Application Reference: 2026/0535

Site Address: Hudroyd House, Genn Lane, Ward Green, Barnsley, S70 6NW

This application seeks full planning permission for the erection of extension to existing detached garage and replacement of flat roof with pitched roof (retrospective)

Drawing
Previously approved & Proposed Plans, Elevations
& Block Plan

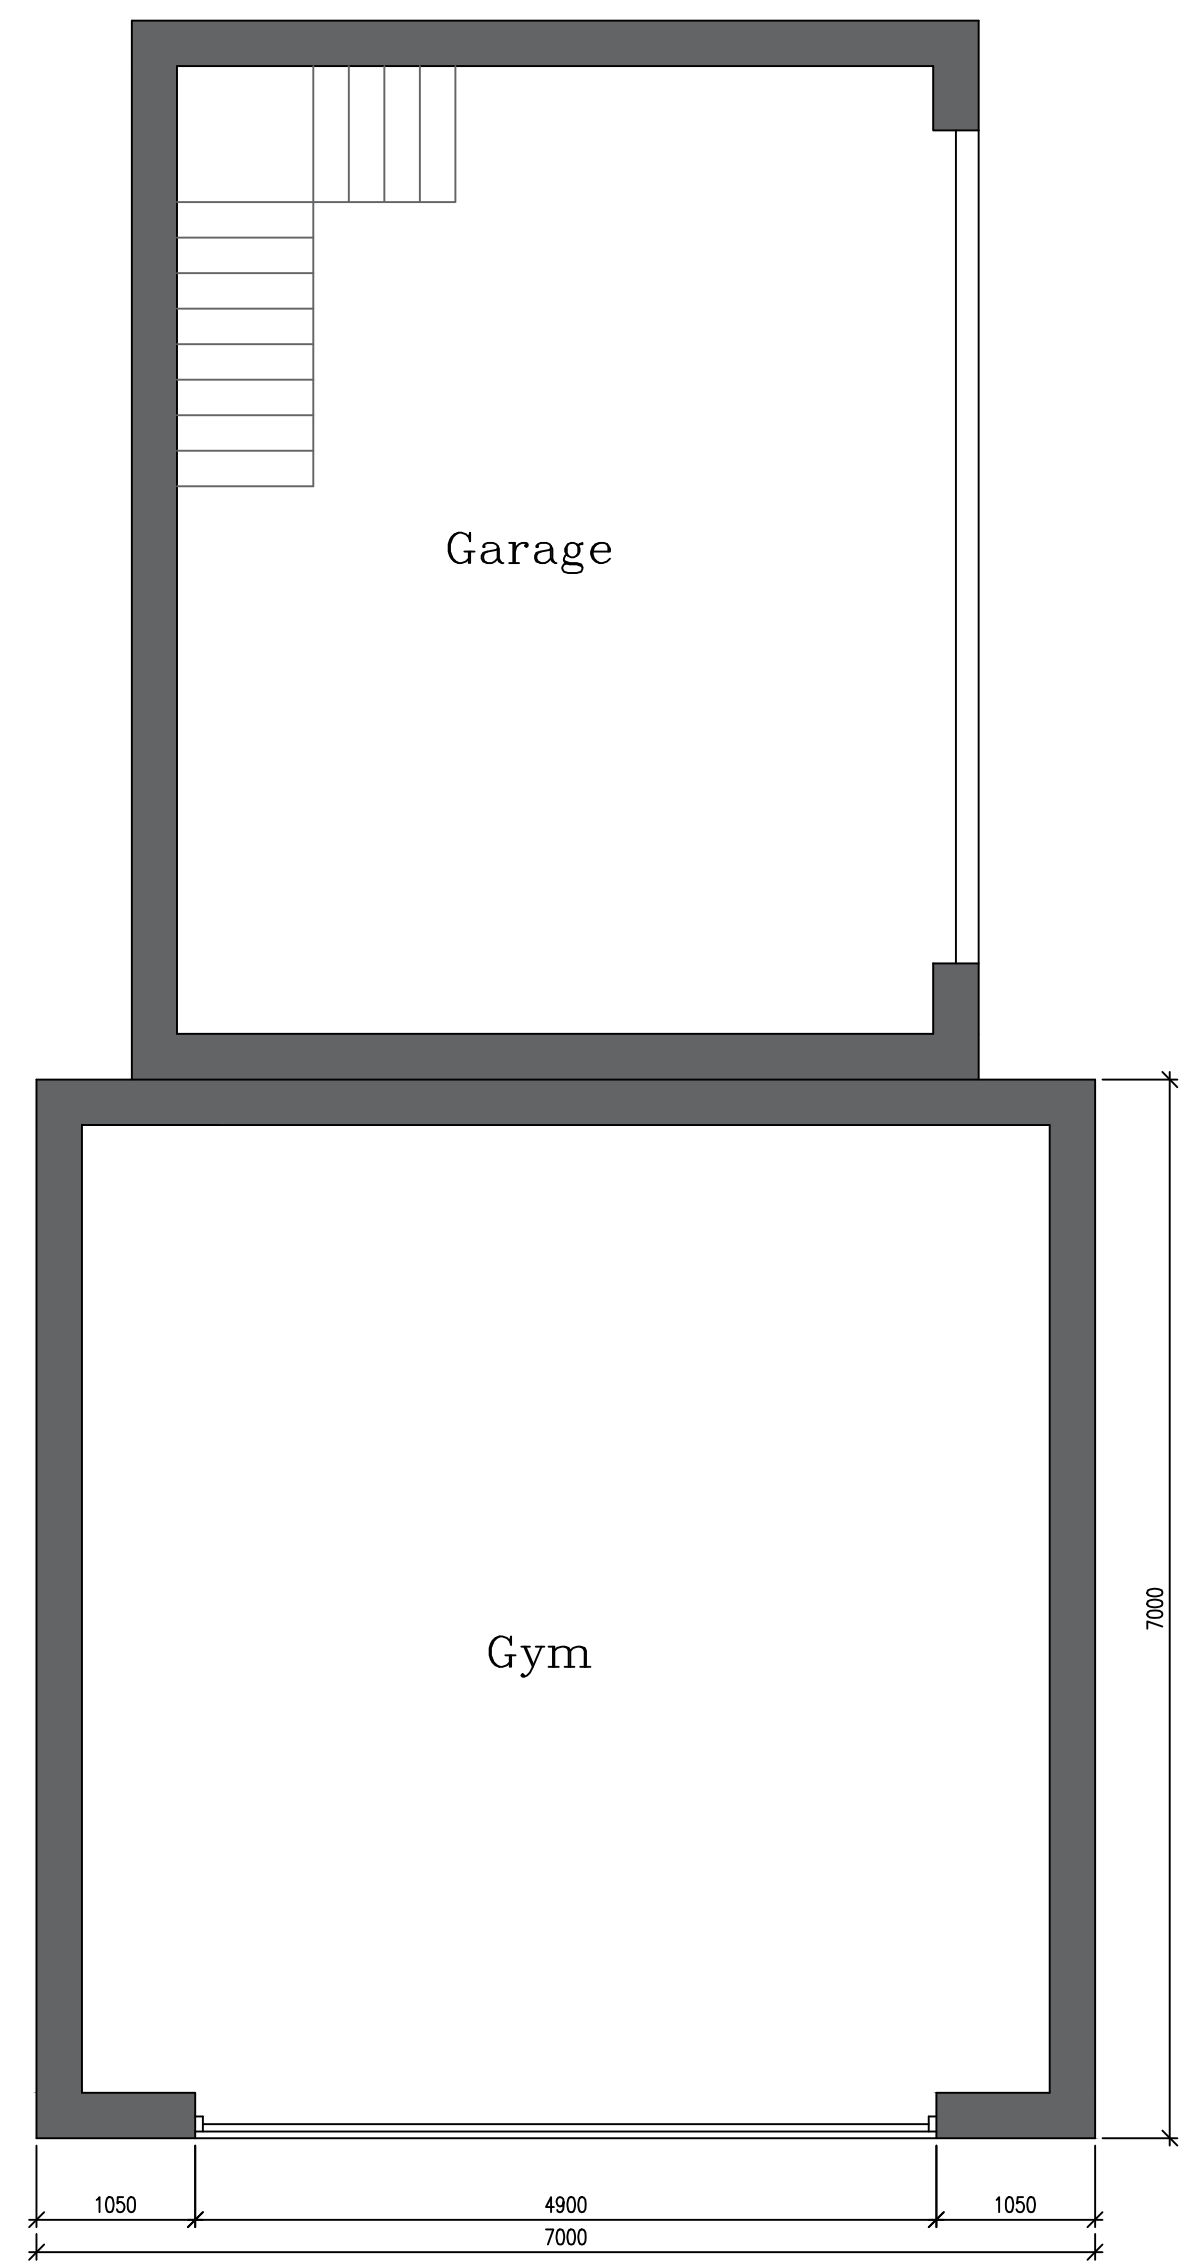
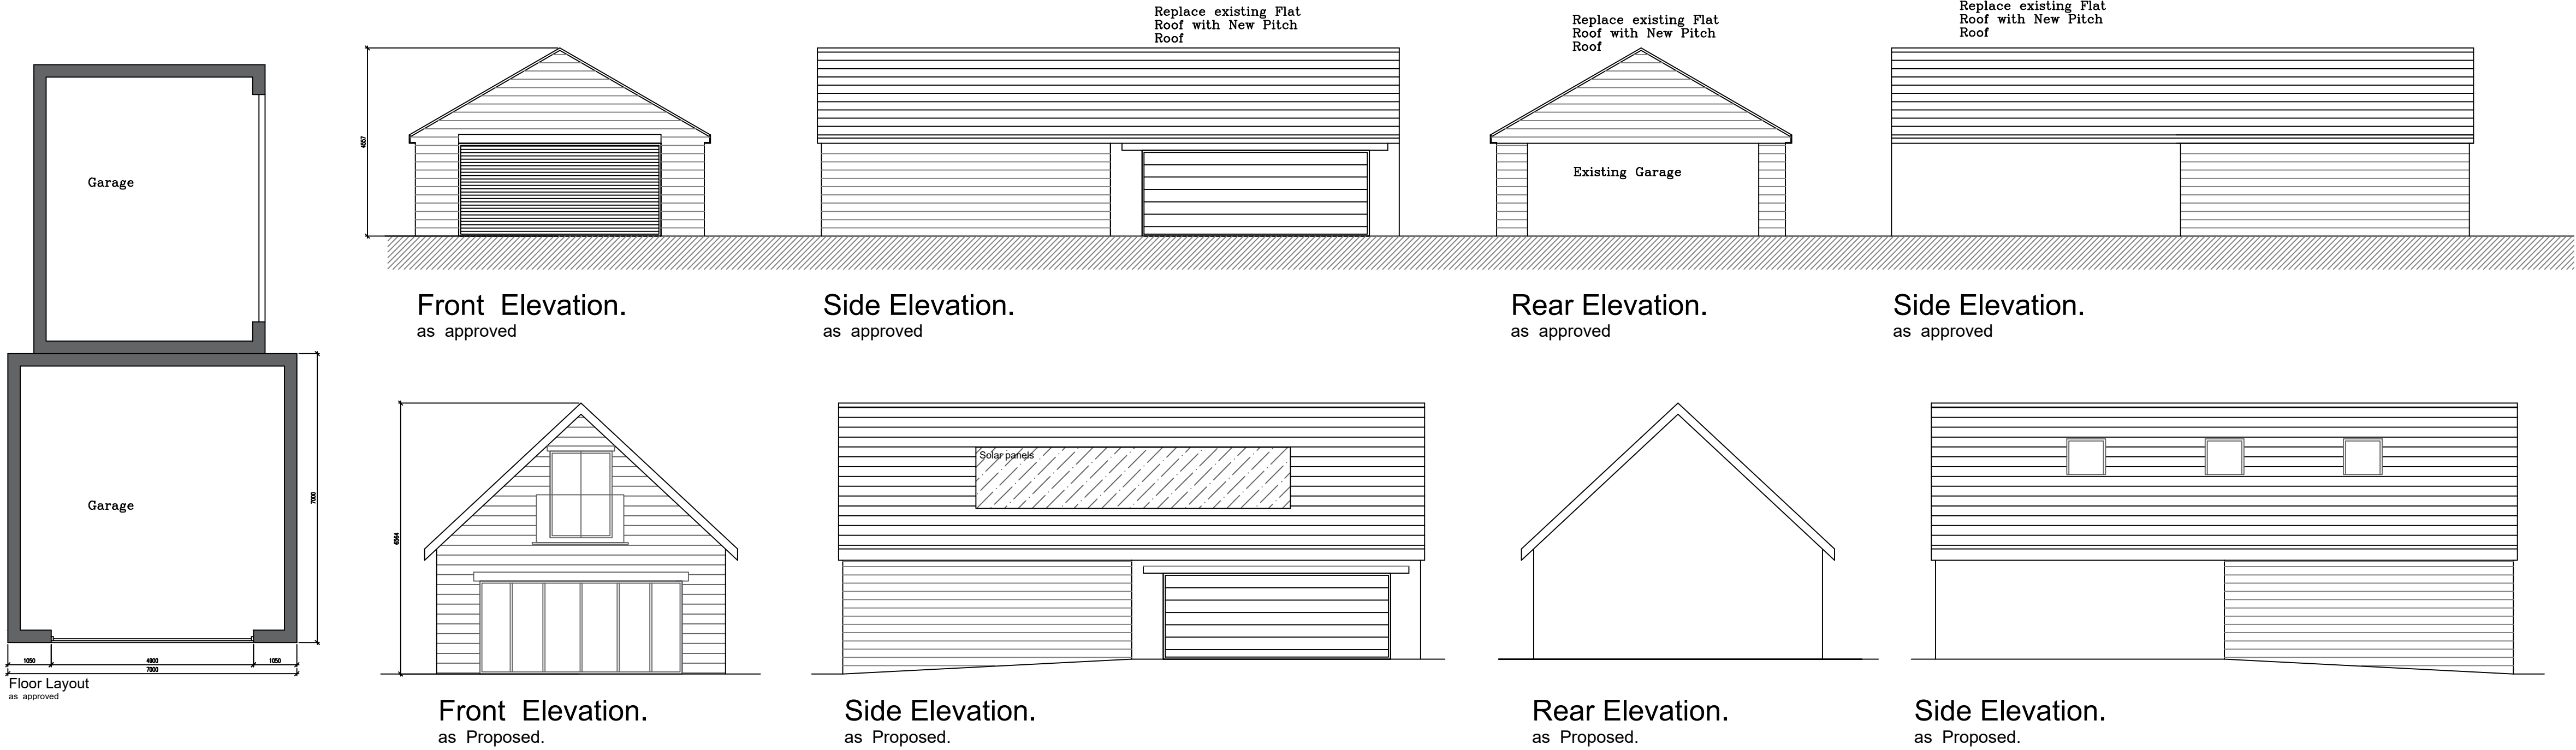
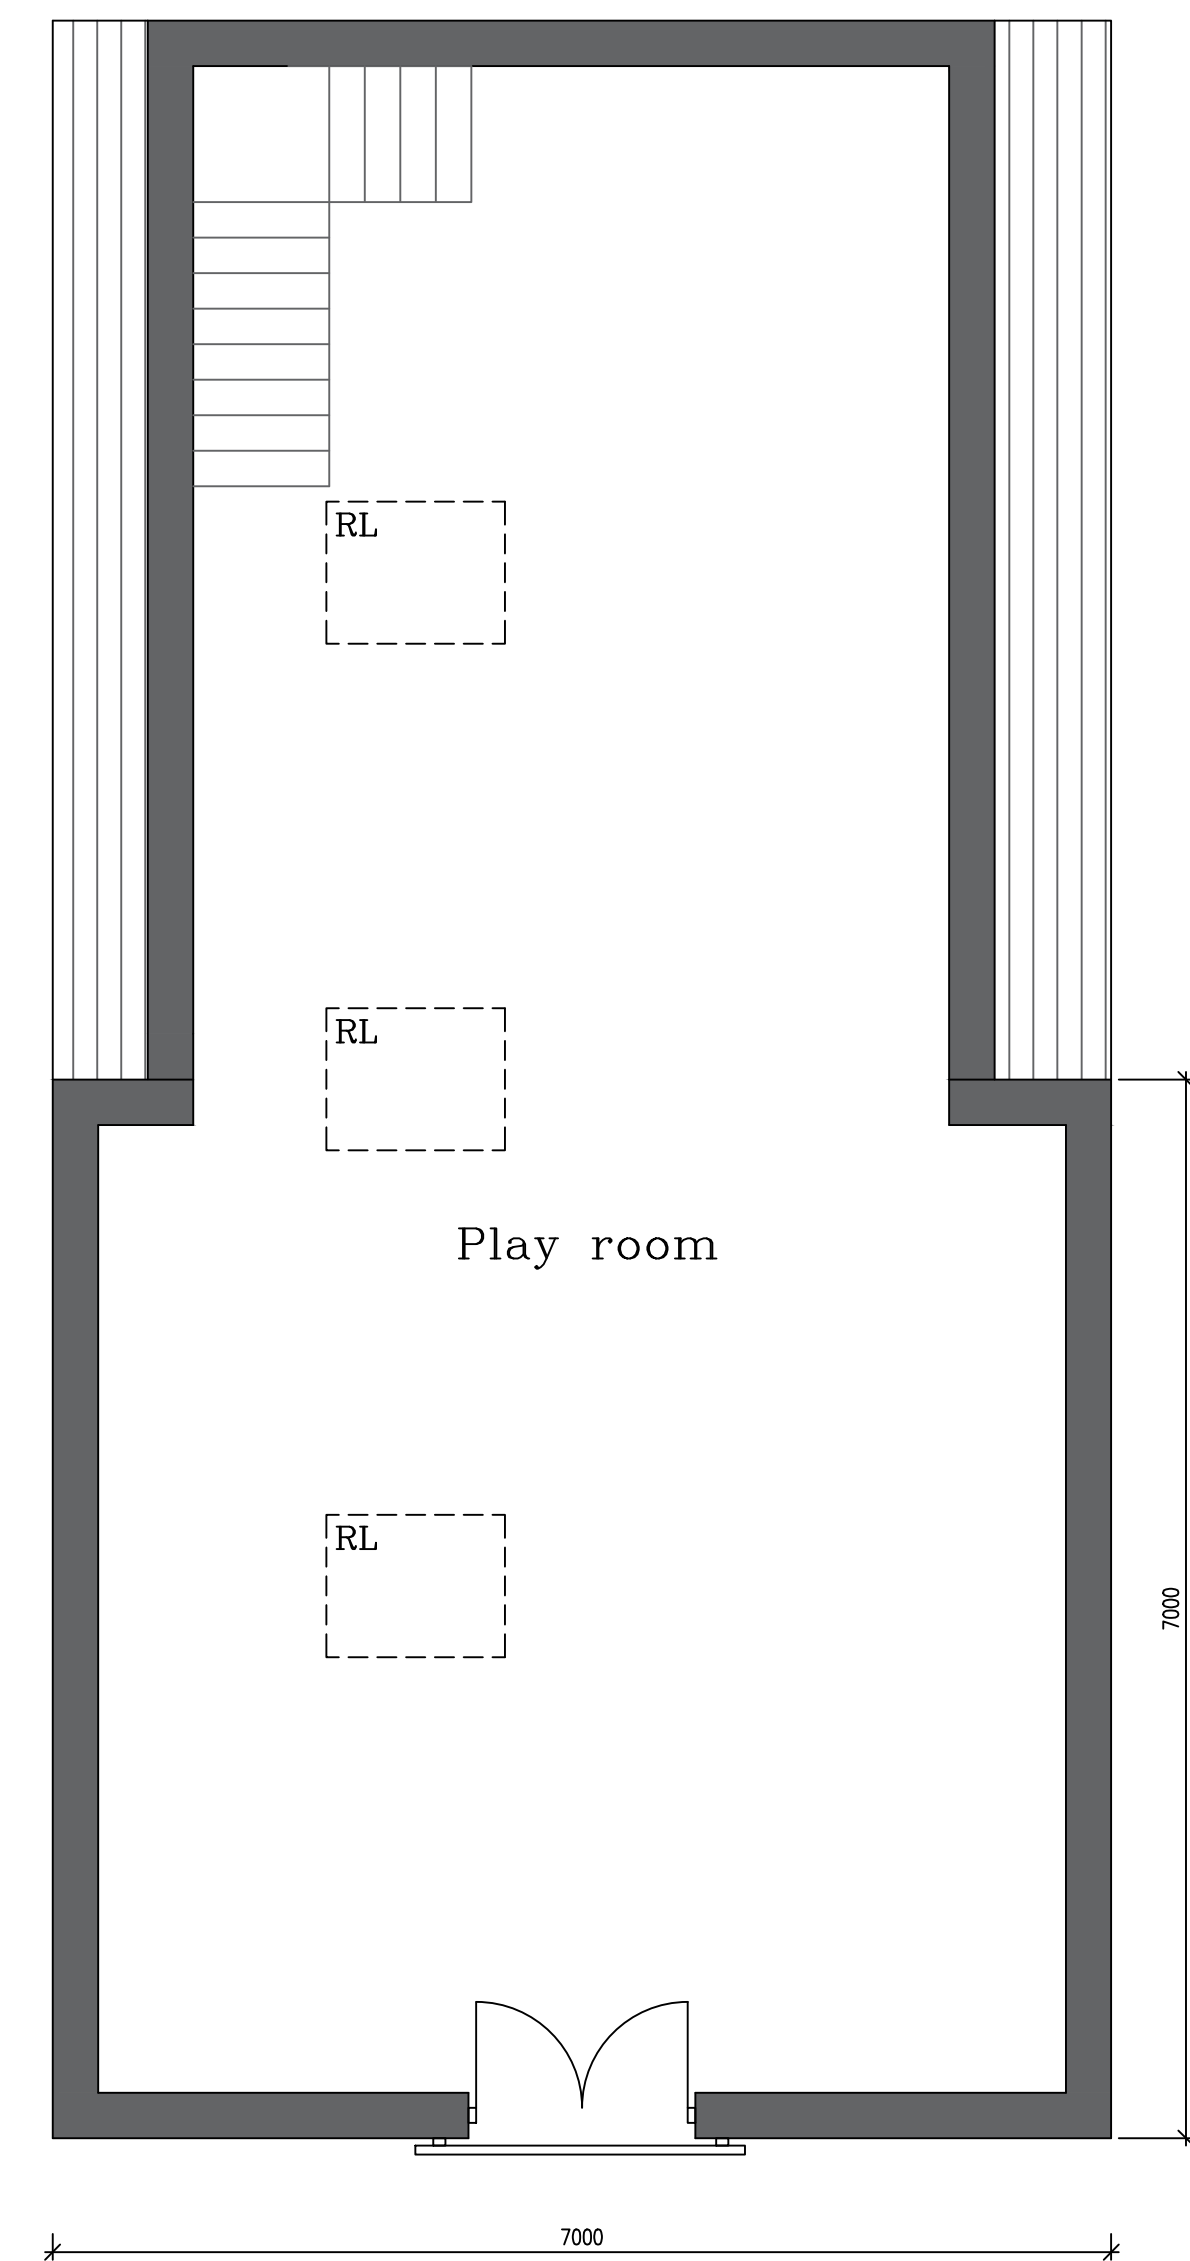
The application relates to the erection of an extension to the existing detached garage and the installation of a pitched roof. The extension is proposed on the southern elevation of the existing garage and would not result in any material increase in overshadowing, overlooking or loss of outlook to neighbouring dwellings. The principal matter for consideration, and the issue raised in representations, relates to the increase in the roof height compared to that approved under application 2026/0045.

Whilst the outbuilding is situated to the south of the closest neighbouring dwelling, 1 Hudroyd Cottages, it is located within its building line and does not project beyond it. Although the ridge height would increase by approximately 2m compared to the previously approved scheme, the building remains detached from neighbouring dwellings and is separated from the neighbouring property by the respective driveways serving both sites. The outbuilding would be positioned approximately 6.3m from the shared side boundary and approximately 10m from the side elevation of the neighbouring dwelling. Consequently, any additional shadowing associated with the increased roof height would largely fall across these intervening areas rather than directly affecting the neighbouring dwelling or its principal amenity space.

Concern has also been raised regarding overlooking from the proposed first-floor playroom. It is acknowledged that a window is proposed at first-floor level; however, this opening would be located within the southern elevation and would face back into the application site and away from neighbouring dwellings. The proposed rooflights would be positioned within the western roof slope and similarly would not provide direct views towards neighbouring habitable room windows or private garden areas. The proposal would therefore not result in any material increase in overlooking or loss of privacy. This carries limited weight against the application.

Comments have also been made regarding potential glare arising from the proposed solar panels on the eastern roof slope. Whilst these concerns are acknowledged, there is no substantive evidence to demonstrate that the proposed panels would result in significant harm to neighbouring occupiers through reflected glare. Solar Panels can be installed without planning permission, and national planning policy provides strong support for renewable and low-carbon energy technologies and for measures that improve the energy efficiency of existing buildings. NPPF National Decision-Making Policy CC2 states that substantial weight should be given to the benefits of improving the energy efficiency of existing buildings by drawing energy from renewable and low-carbon sources, including solar panels. Consequently, this matter carries limited weight against the development, whilst the environmental benefits attract substantial weight in favour of the proposal.
